I have looked at the Appendix 7.3 Wintering Bird Survey Report this morning. Whilst I appreciate the developers have a large area in which to survey this survey is insufficient and inadequate in many areas.

Functional Connectivity is not constrained by arbitrary distance buffers. With Field 312 only being surveyed in the latter winter survey and being highlighted as important, this requires a 2nd wintering bird survey. The identification of Field 44 meeting the Functionally Linked Land criteria for the Upper Nene Valley SPA shows that Golden Plover, as a mobile species, actually uses this field for core activities like feeding, roosting or loafing. It means that further Winter Bird Surveys are required, undertaken to meet Natural England's strict requirements. This evidence shows that there is a requirement for a Habitats Regulation Assessment. The law is strict, under the Habitats Regulations, a project cannot bypass this assessment if there is a potential risk to a protected habitat site. The Planning Inspector / Secretary of State must ensure a HRA is completed before consent can be granted.

Drawing Title
**Wintering Bird Survey
Sheet 1 of 2**

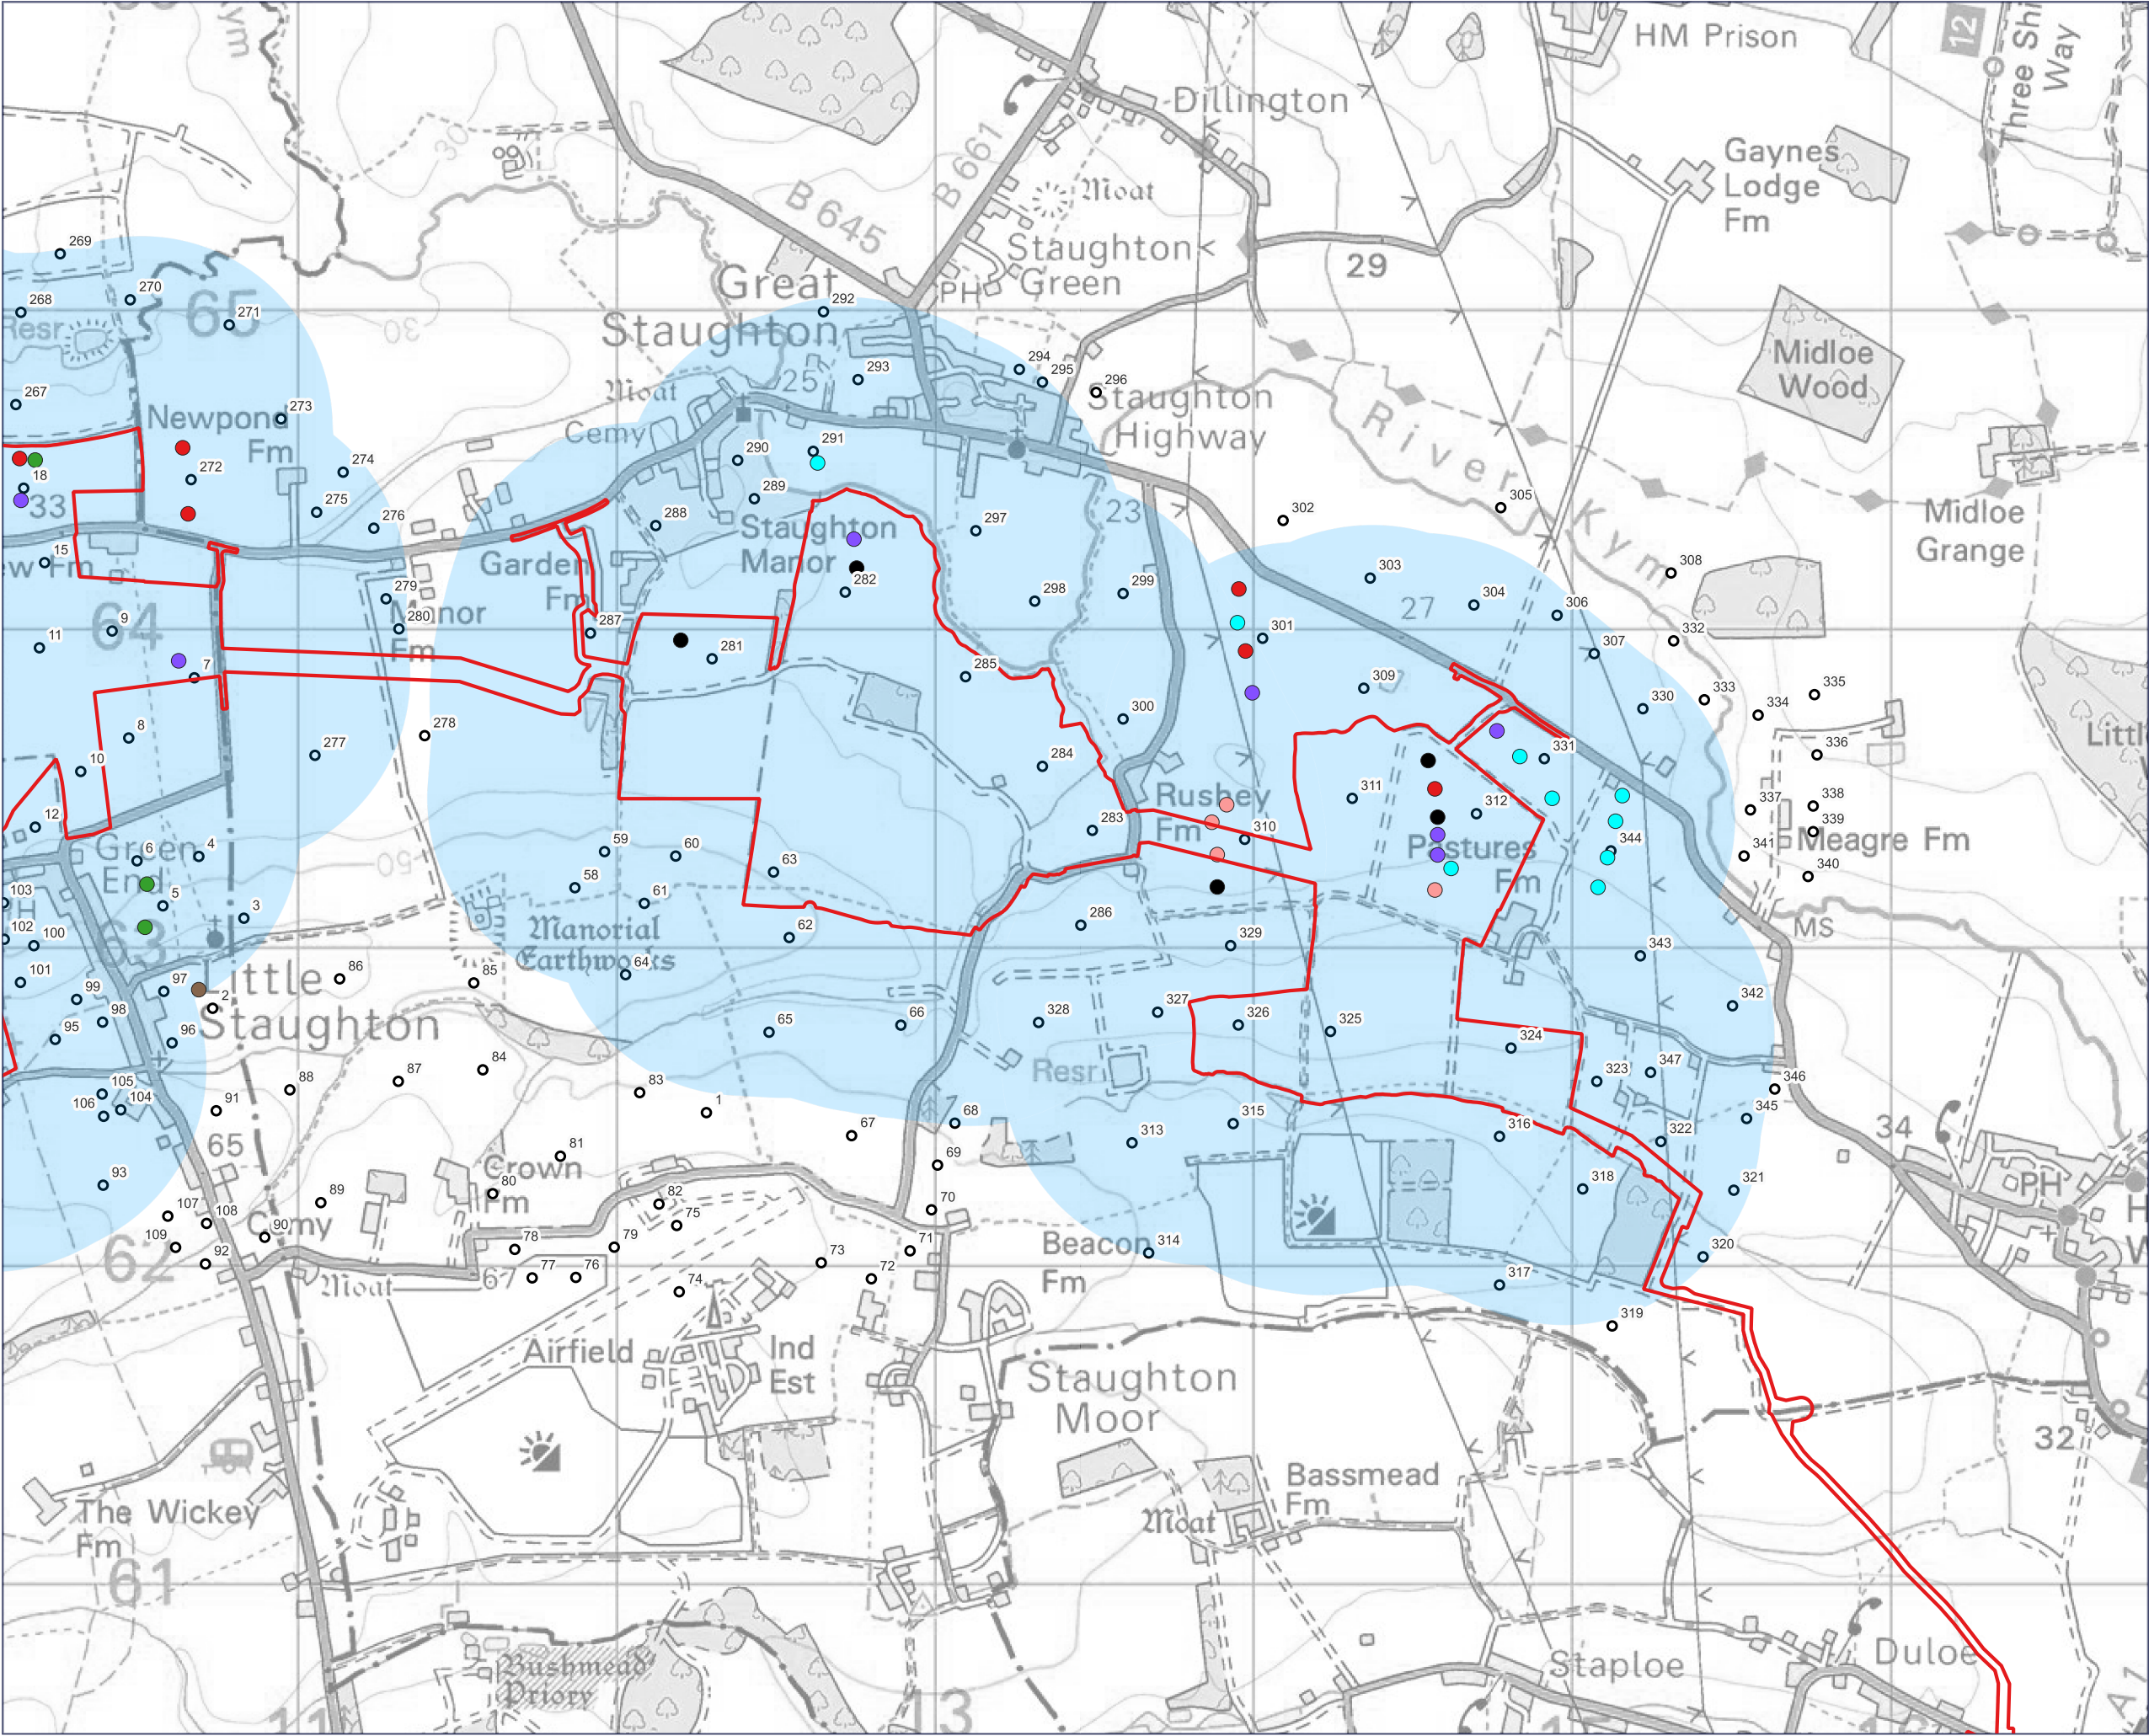
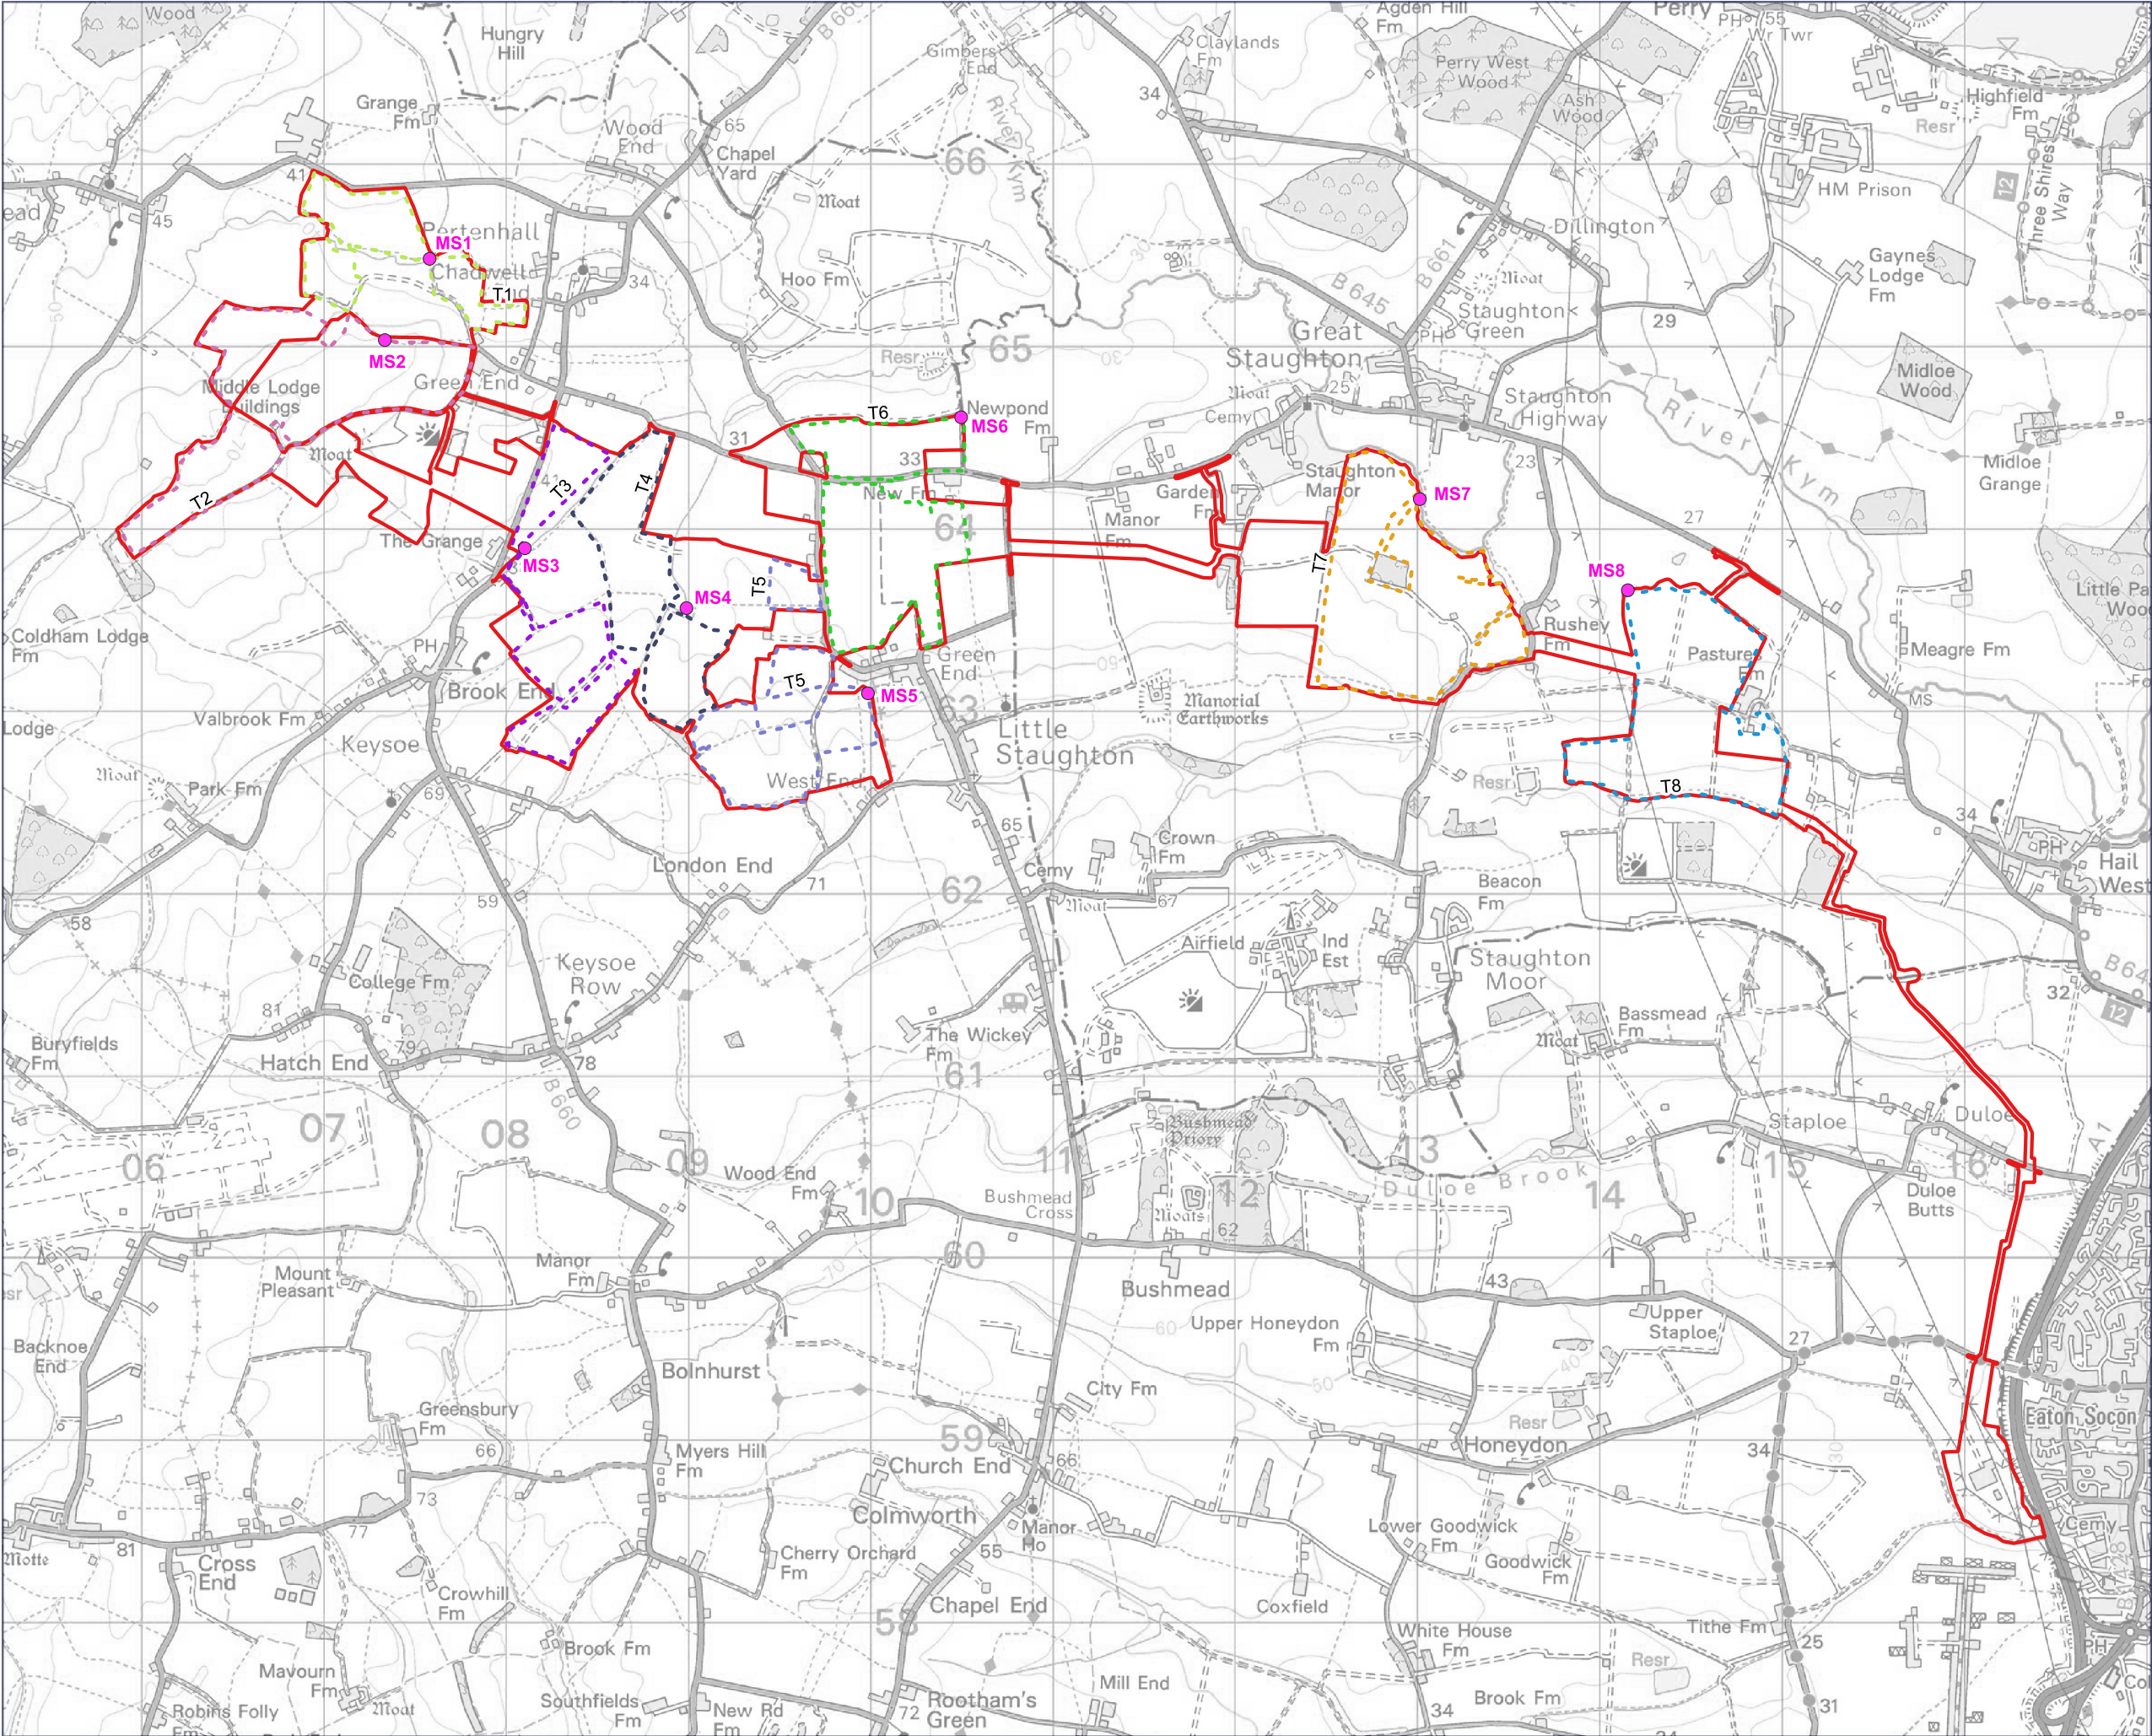
Field 44 - Survey 1 - 107

Field 44 - Survey 1 - 53

Field 312 - Survey 2 - 450

This shows that Field 44 is vitally important to Golden Plover, it qualifies as Functionally Linked Land to the Upper Nene Valley SPA as had more than 1% of the cited population sighted on more than one occasion over successive years. It is just over the arbitrary 10km limit, being 11.5km from the SPA at its closet point.

Field 312 had a high count of 450 Golden Plover and 500 Lapwing is also very significant flock of SPA qualifying birds.
